APPLICATION NO.	03DRB-00134	PROJECT NO.	1002094
PROJECT NAME	La Tierra Que Canta		
EPC APPLICATION NO.			
APPLICANT / AGENT	Wayjohn Pete	PHONE NO.	255 2052
ZONE ATLAS PAGE	G-12

**CITY OF ALBUQUERQUE**  
**Planning Department**  
**DRB Comments**  
**2/5/03**

**Subject:** La Tierra Que Canta/Final Plat

PLAT OF
LA TIERRA QUE CANTA
 A PRIVATE COMMON AREA SUBDIVISION
 ALBUQUERQUE, BERNALILLO COUNTY, NEW MEXICO
 A REPLAT OF LOT "A" ALVARADO GARDENS UNIT 2
 SECTION 1, T.10N., R.2E., N.M.P.M. (PROJECTED)
 WITHIN THE TOWN OF ALBUQUERQUE GRANT

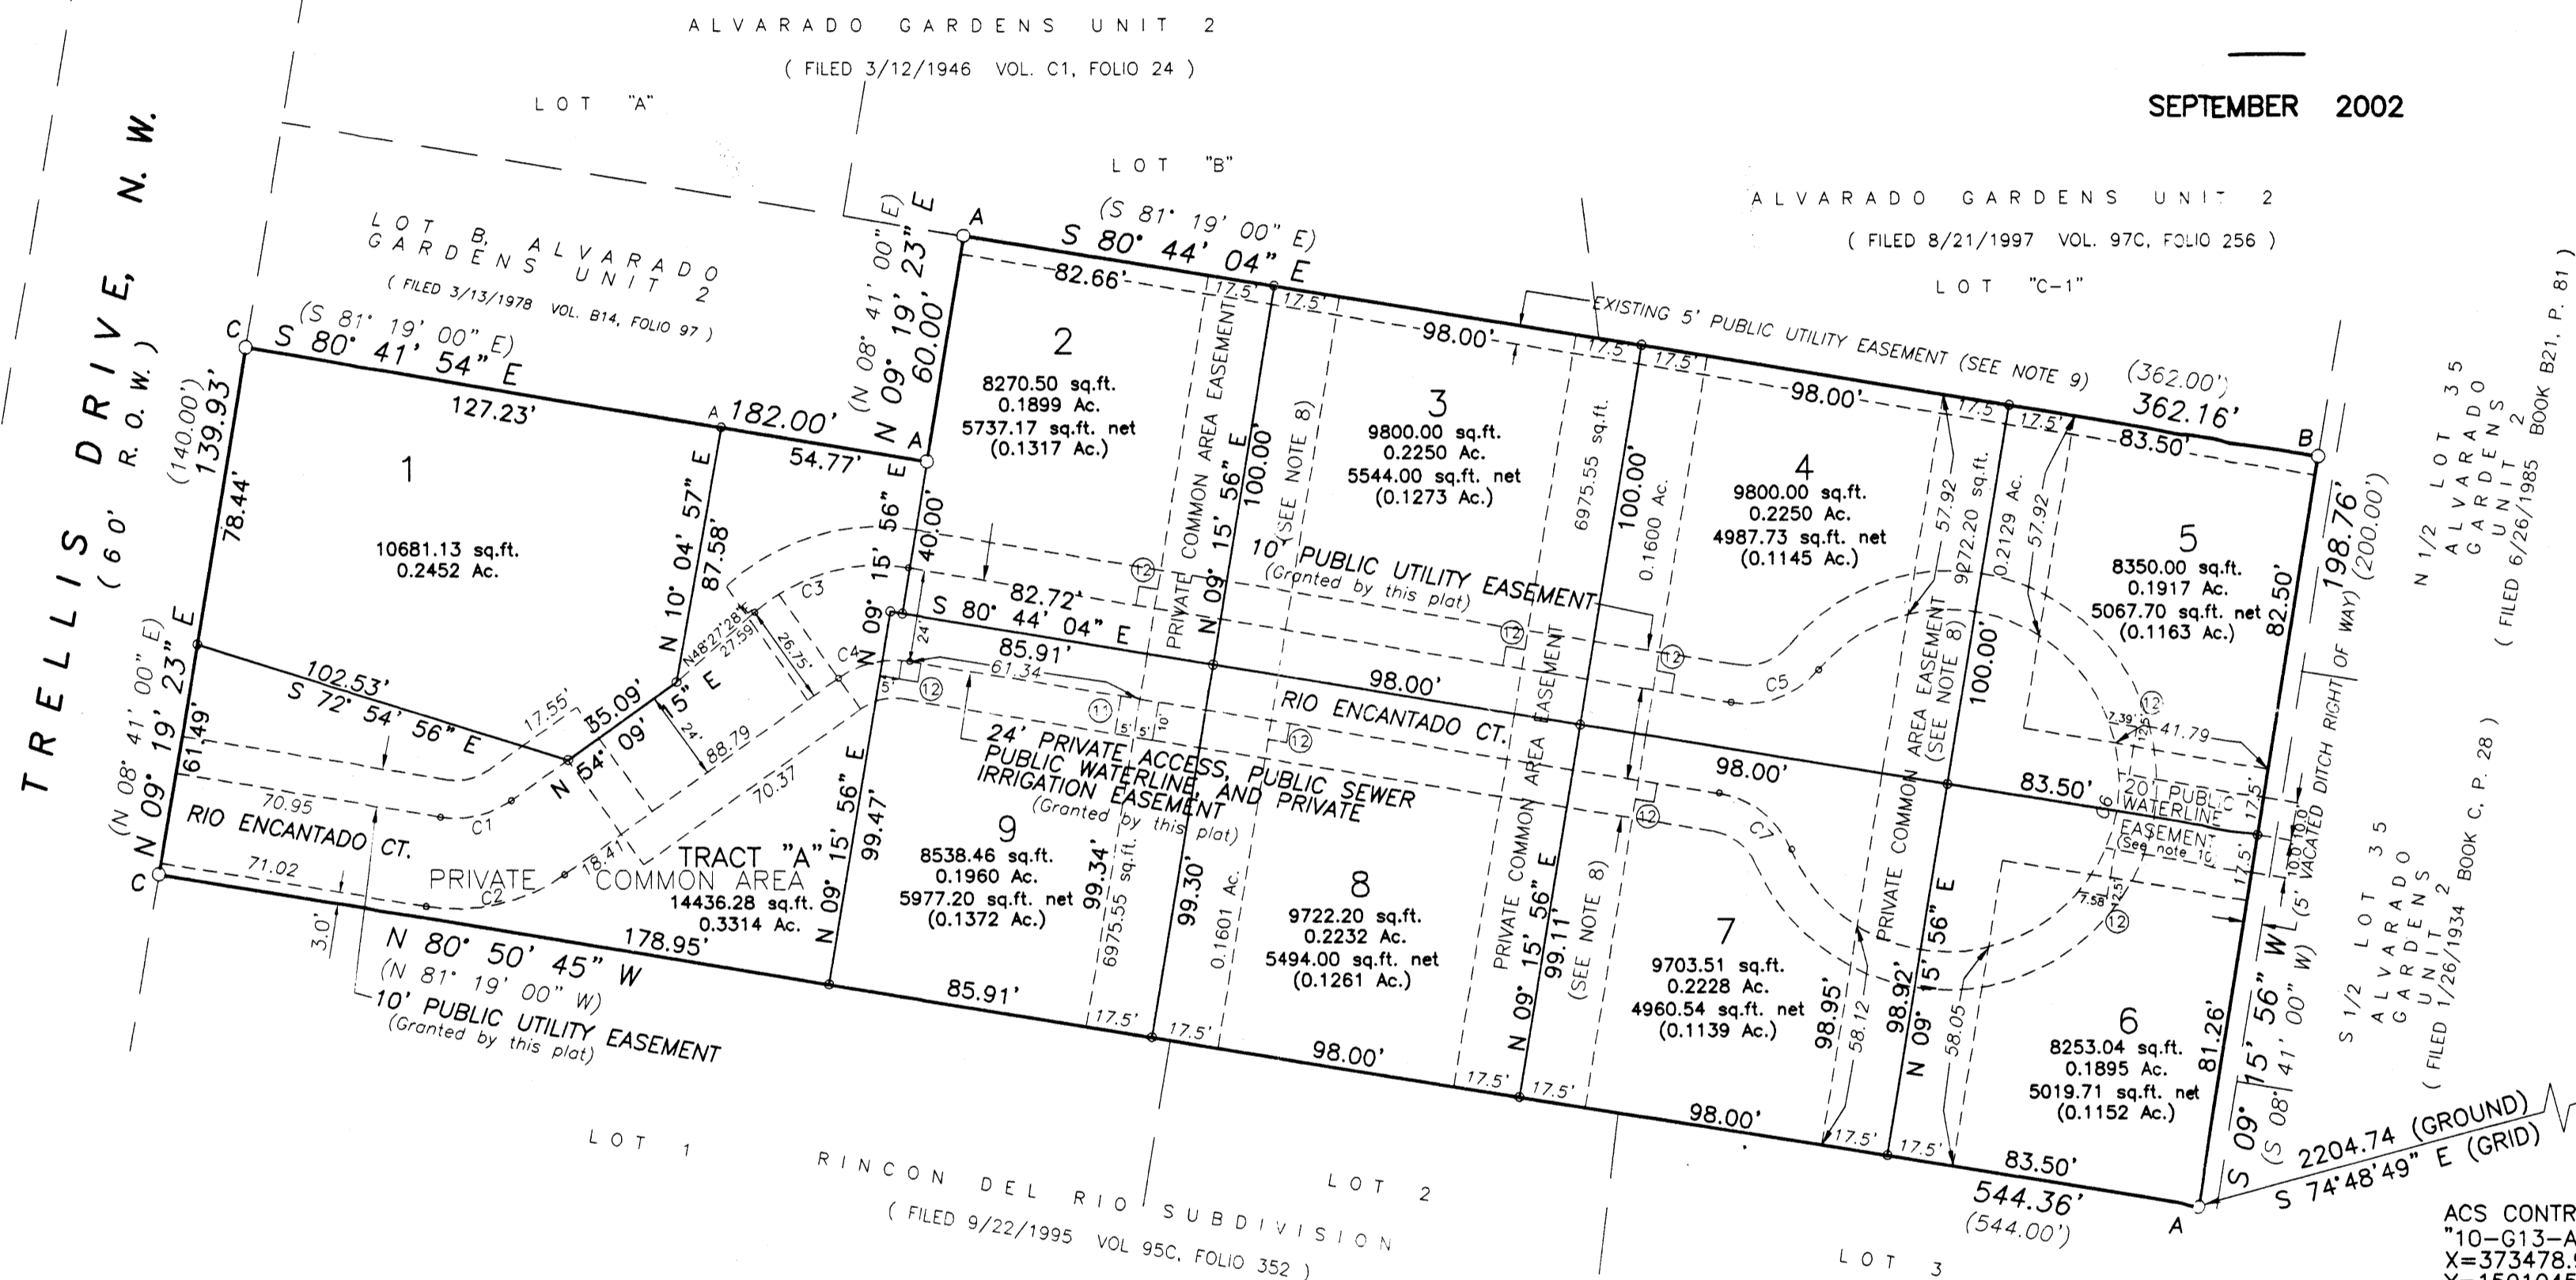
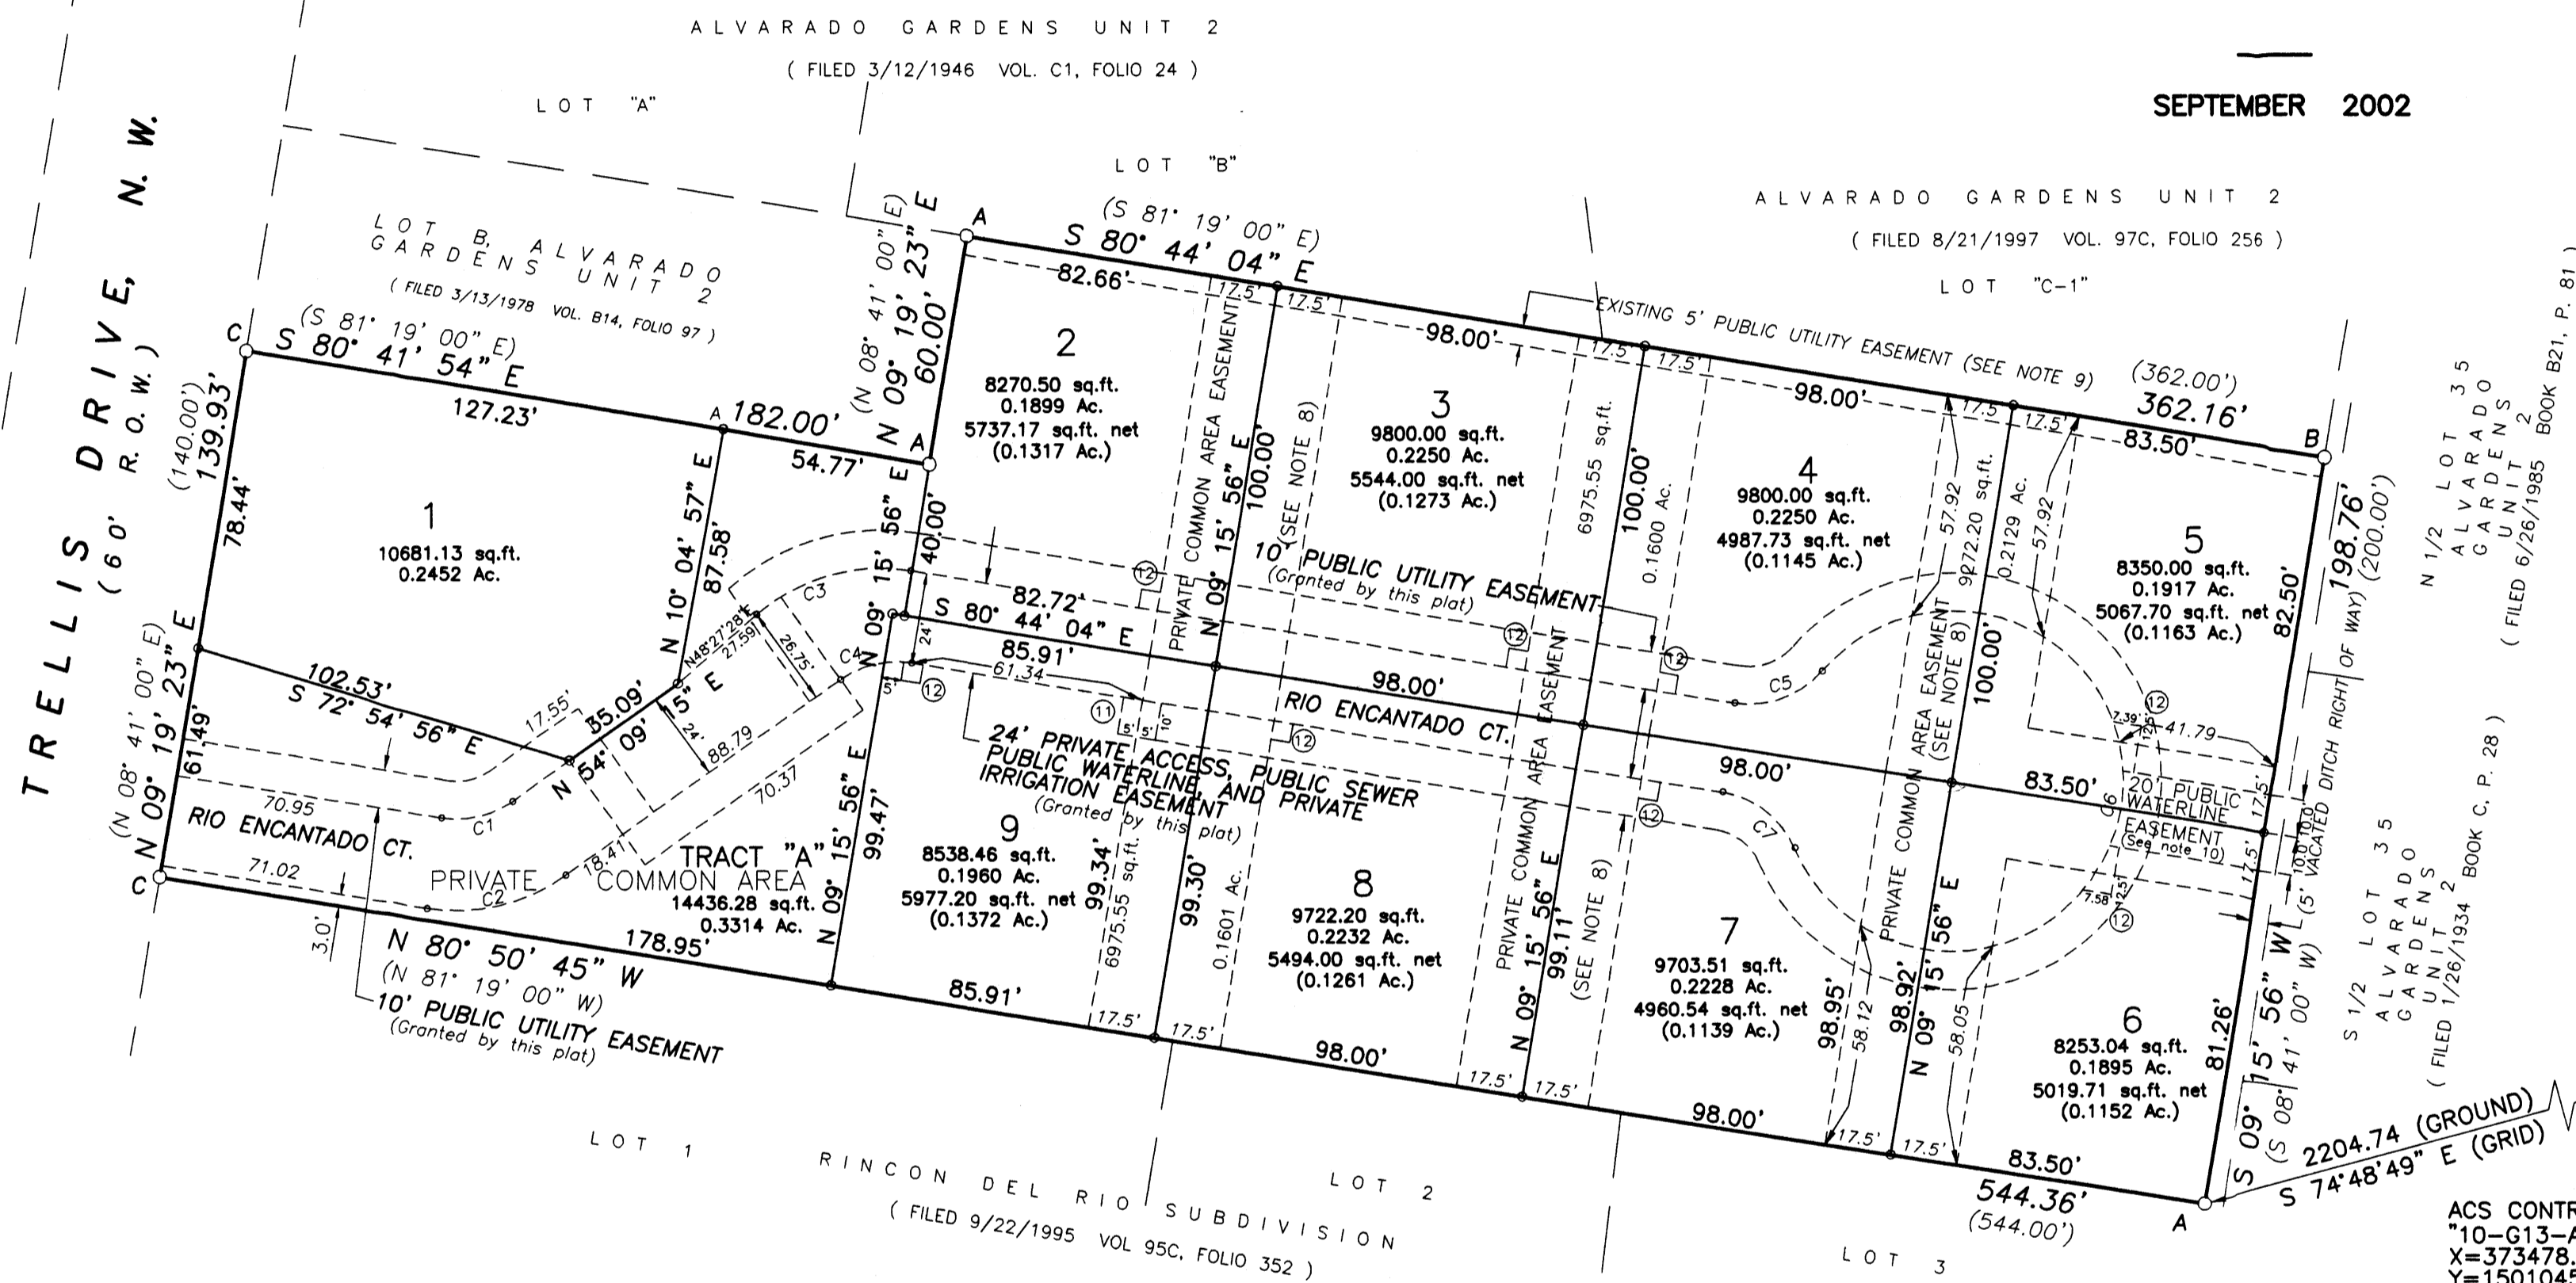
Section 14-16-3-11 (G) (1) of the City Comprehensive Zoning Code states:

“Convenants shall be in the form of deed restrictions and shall be referenced on the subdivision plat.”

This language is missing from the final plat as is language in Section 14-16-3-11 (G) (5), also required for this Private Commons Development.
